WEST SUSSEX COUNTY COUNCIL CONSULTATION

TO:	Arun District Council FAO: Stuart Corbey
FROM:	WSCC - Highways Authority
DATE:	29 March 2019
LOCATION:	Building West of 131 Sea Road, Littlehampton, BN16 1PD
SUBJECT:	EP/180/18/PL Change of use of boat store & sail loft (Sui Generis) to a single residential dwelling (C3 - Dwellinghouse) & part change of use of former dinghy pen to caravan site (Sui Generis).
DATE OF SITE VISIT:	N/A
RECOMMENDATION:	Advice
S106 CONTRIBUTION TOTAL:	N/A

Indicative Site Layout - Drawing No. 3

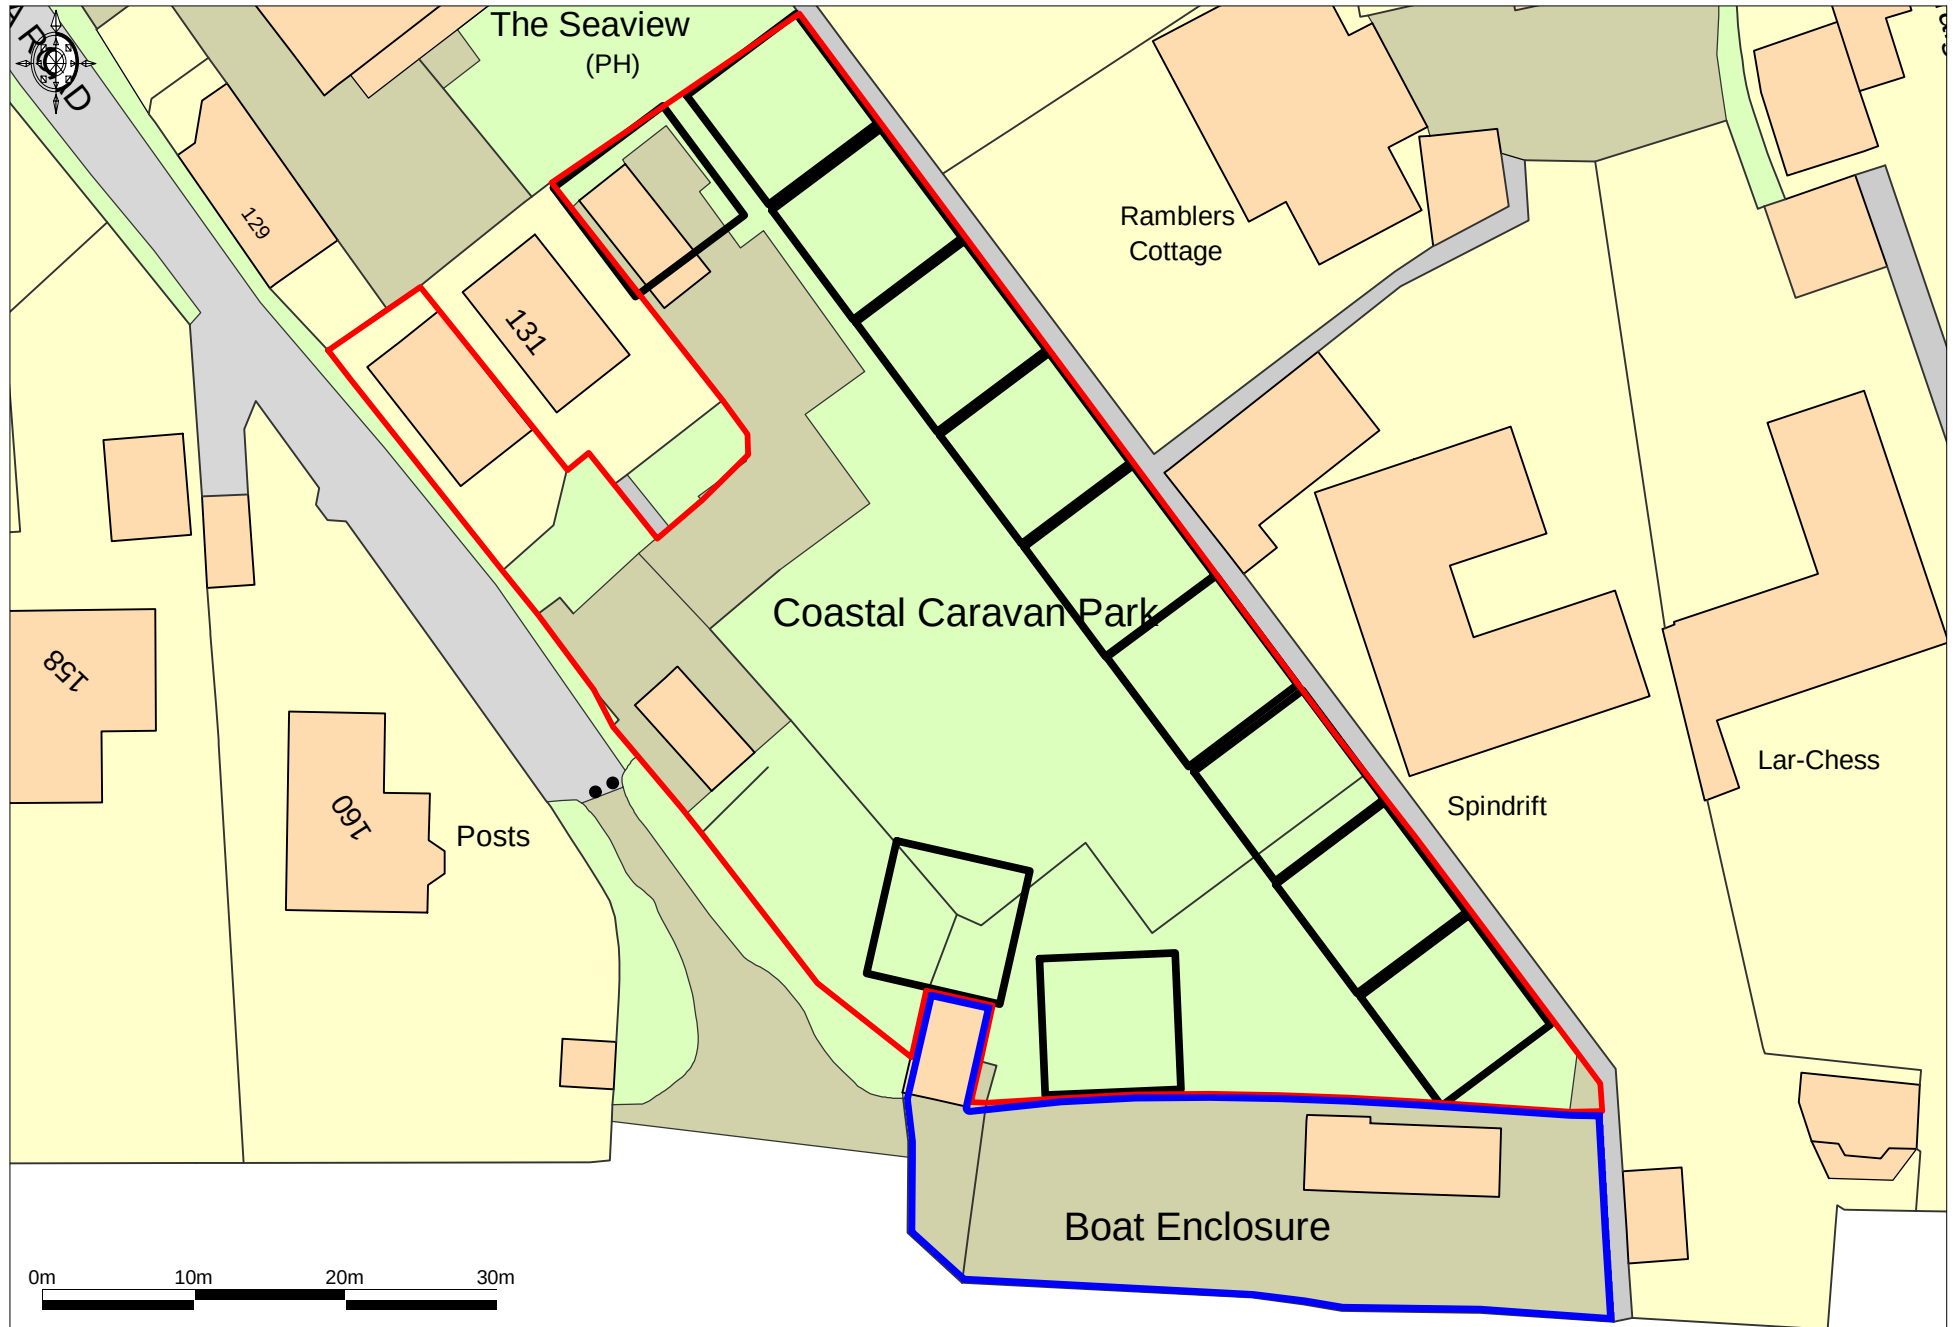
The proposed plans indicate that two parking spaces will be provided for the proposed dwelling. These spaces meet minimum specifications as set out in Manual for Streets (MfS). This is anticipated to be sufficient parking provision for a dwelling of this size and location. There also appears to be sufficient space on site for vehicles to turn and exit onto the public highway in a forward gear. The site is located sustainably, within walking distance of local amenities and services. Cycling is a viable option within the vicinity and details of secure and covered cycle storage can be secured via condition.

Car parking space (details approved)

No part of the development shall be first occupied until the car parking has been constructed in accordance with the approved site plan. These spaces shall thereafter be retained at all times for their designated purpose.
